**Project# 1008060**

09DRB-70344 VACATION OF PUBLIC UTILITY EASEMENT  
09DRB-70345 MINOR - PRELIMINARY/ FINAL PLAT APPROVAL

CITY OF ALBUQUERQUE  
PLANNING DEPARTMENT  
DEVELOPMENT REVIEW BOARD

SURV-TEK INC agent(s) for 6301 UPTOWN LLC request(s) the referenced/above action(s) for all or a portion of Lot(s) A-2-B-1 & B-1-A, **DALE J BELLAMAH'S JEANNEDALE UNIT 5**, zoned SU-3/ MIXED USE-UPT, located on the north side of UPTOWN BLVD NE between SAN PEDRO DR NE and AMERICA'S PKWY NE containing approximately 4.4842 acre(s). (H-18)

SHEET 3 OF 3

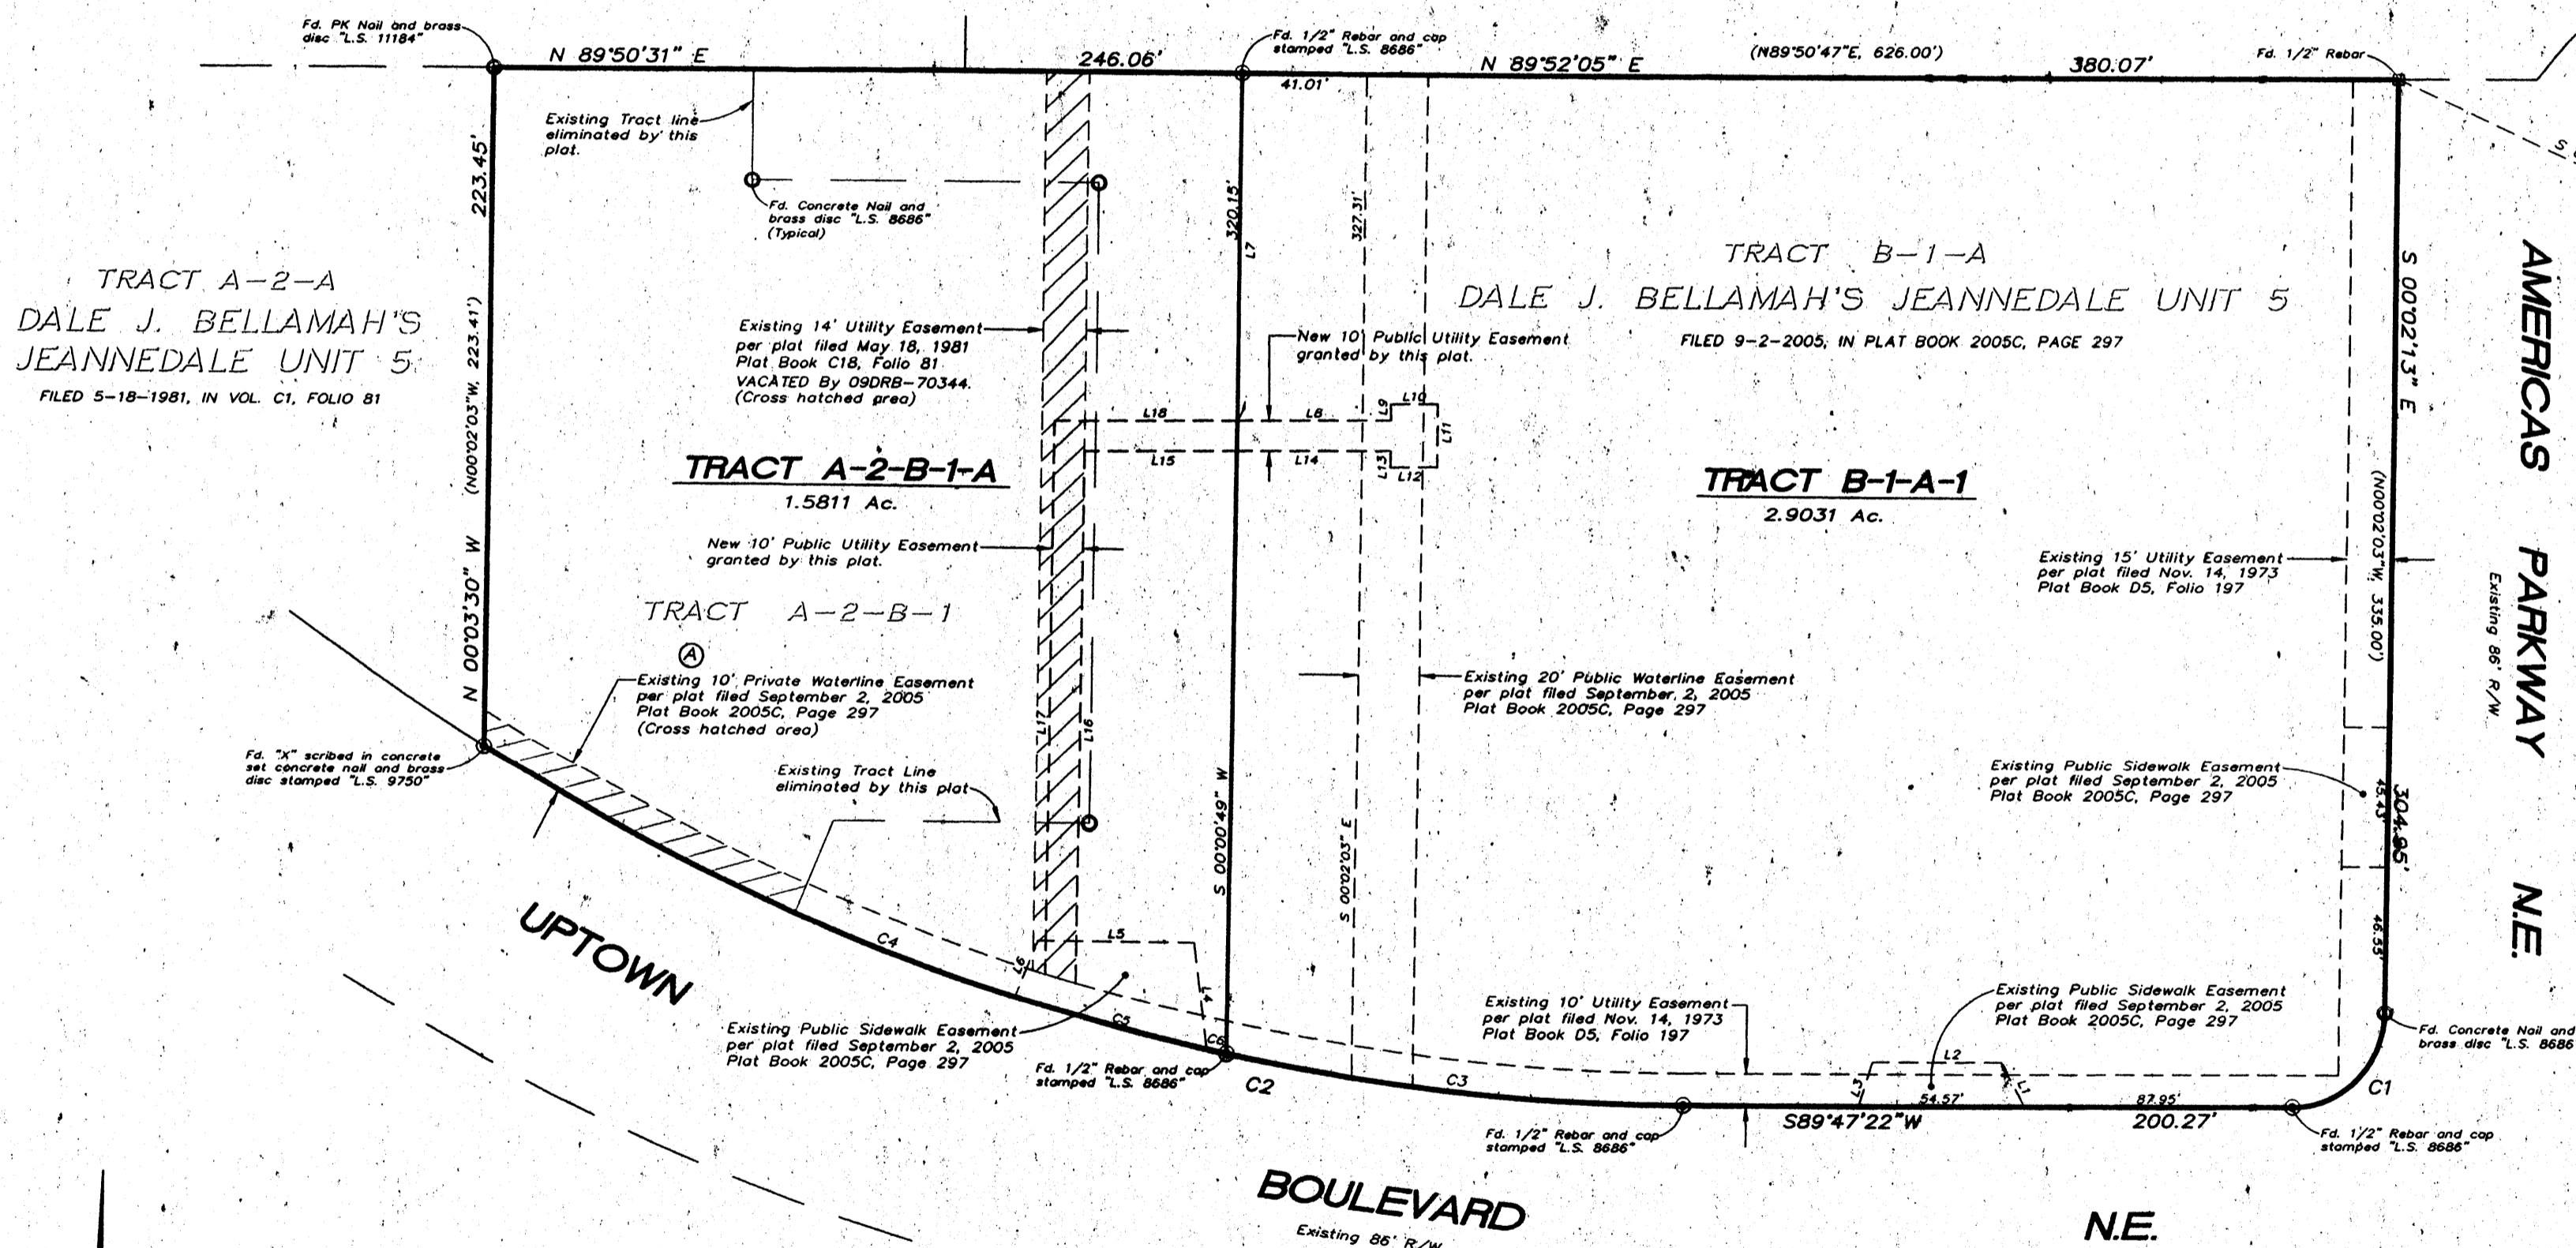
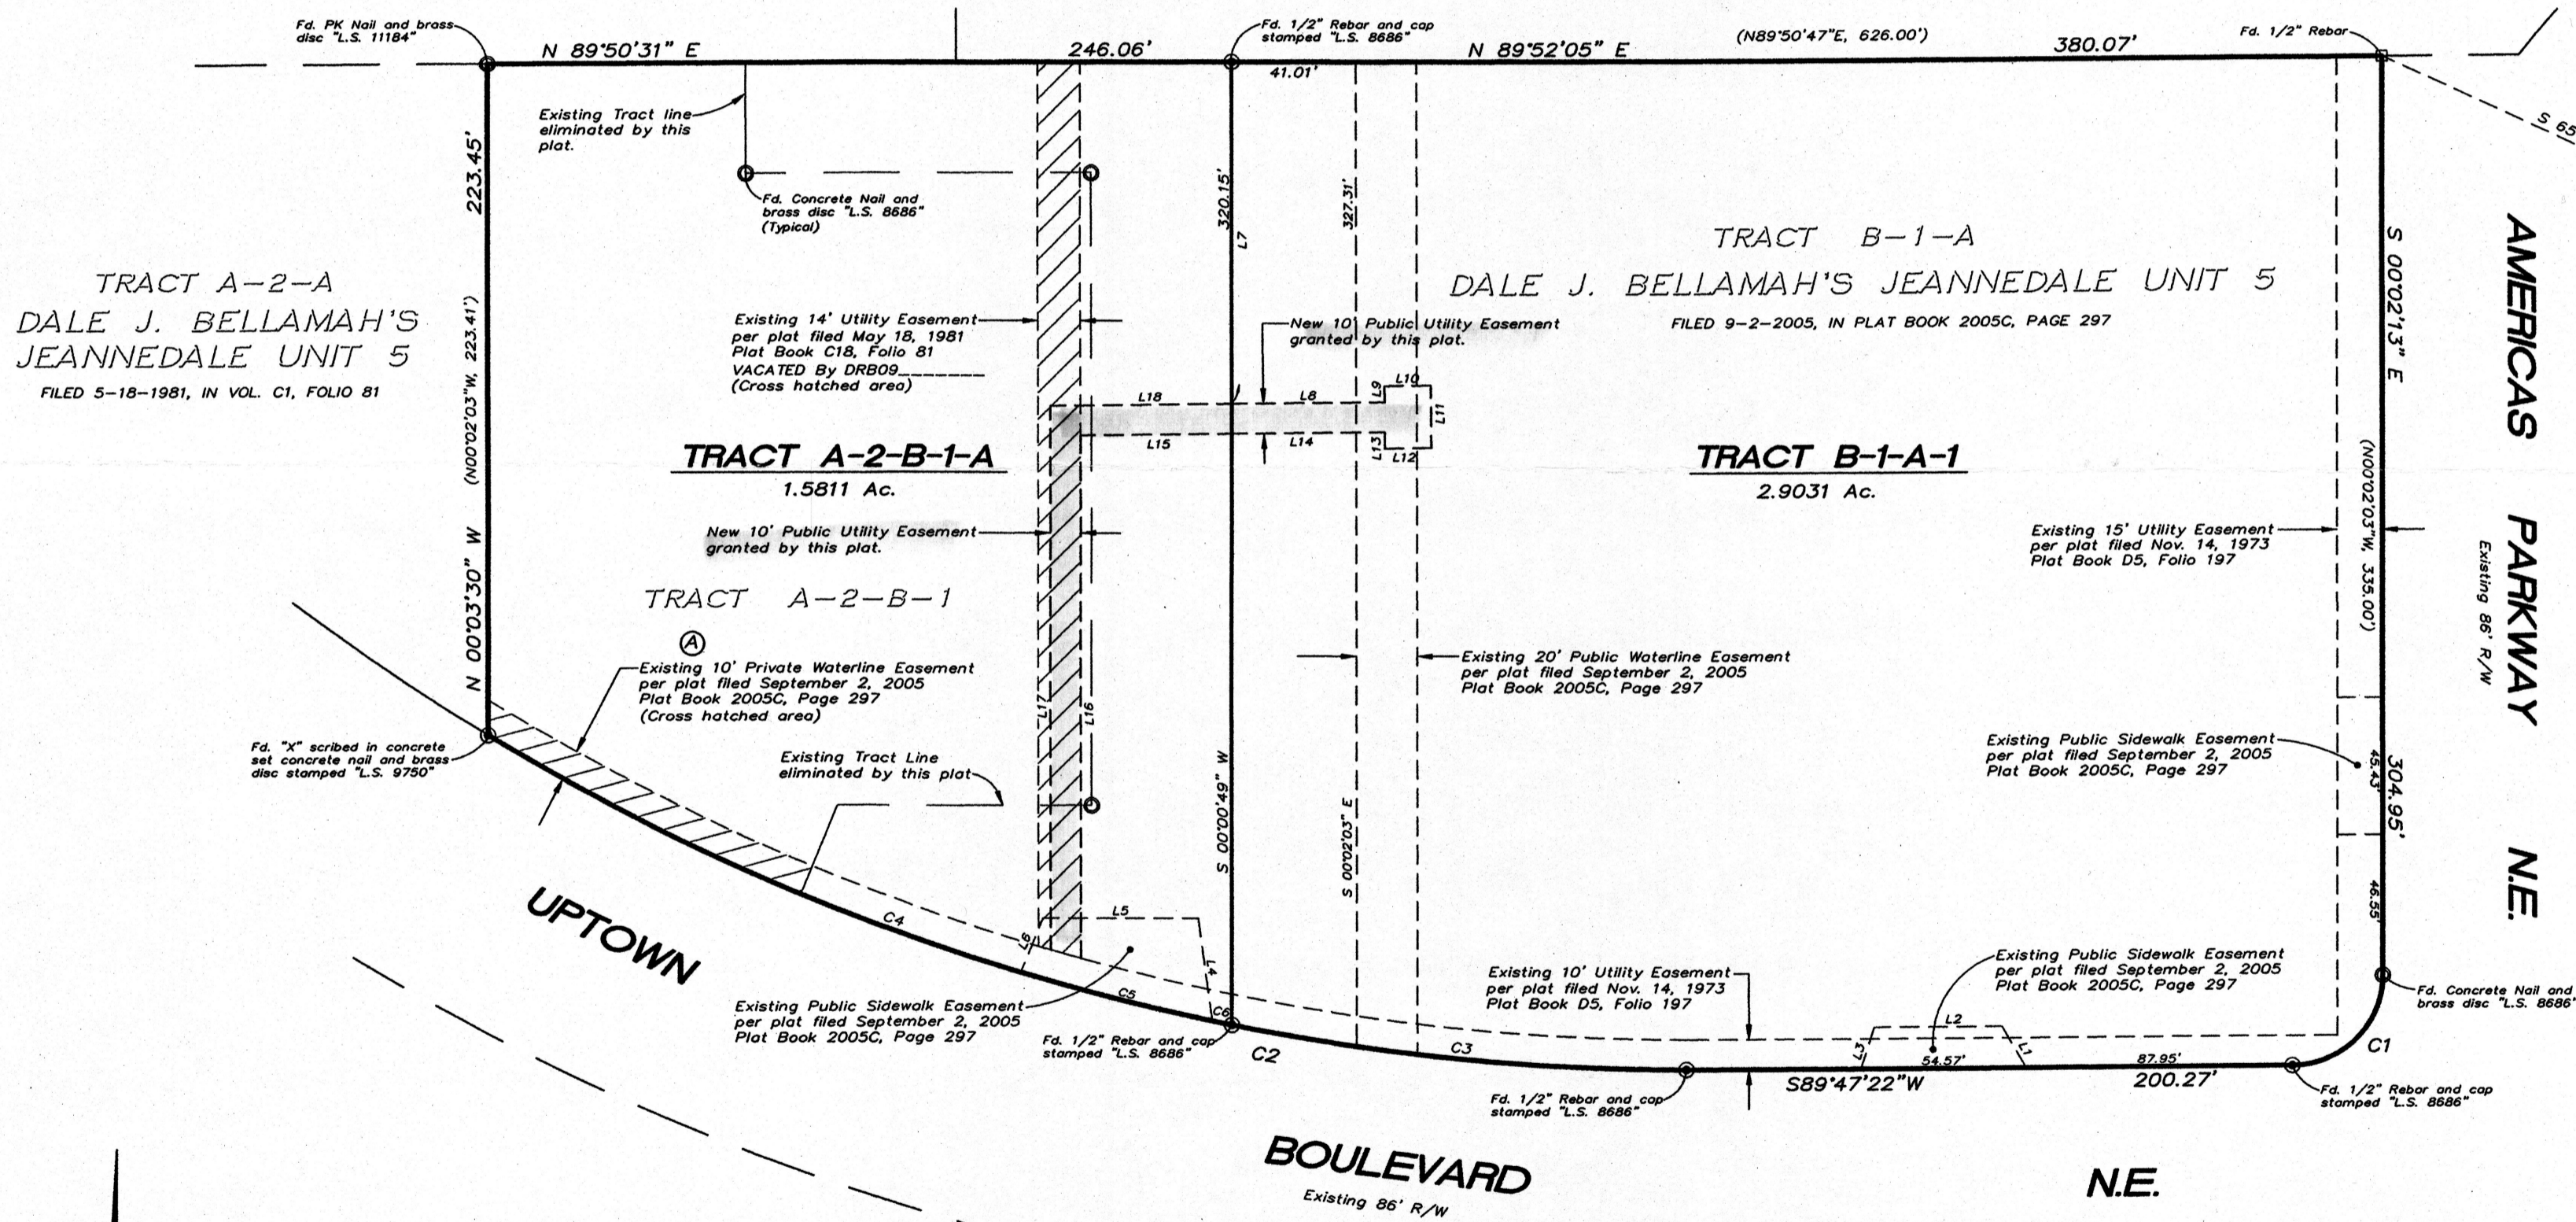
**Vacation of a Public Utility Easement:** PNM will not vacate the easement it supports existing underground facilities.

Concerning the subject case number(s), Qwest cannot comment on the vacation of the public utility easement(s) as submitted; Qwest has existing buried facilities in this area which provides service to addresses 6301 and 6201. Qwest will request the developer to call for locates before the engineer approves of the vacation. If the utilities are found to be within the PUE Qwest will relocate if payment is received for the relocation. Prior to any final plat approval, we will need a copy for review. If specific information is required concerning the requested easement vacation, please contact Richard Redman at 245-6098.

No objection to vacation request.  
Provide an exhibit showing the location of sidewalk and defining the distance from face of curb to the property line. Right of way dedication may be required.

This is acceptable to PNM. Thank you for making these adjustments.

Per your request we have had the line spotted and located the existing transformer. I have created a new public utility easement to cover said infrastructure (see attached). Please let me know if this is agreeable to you as soon as possible so that I may get corrected copies to DRB for tomorrow mornings hearing.
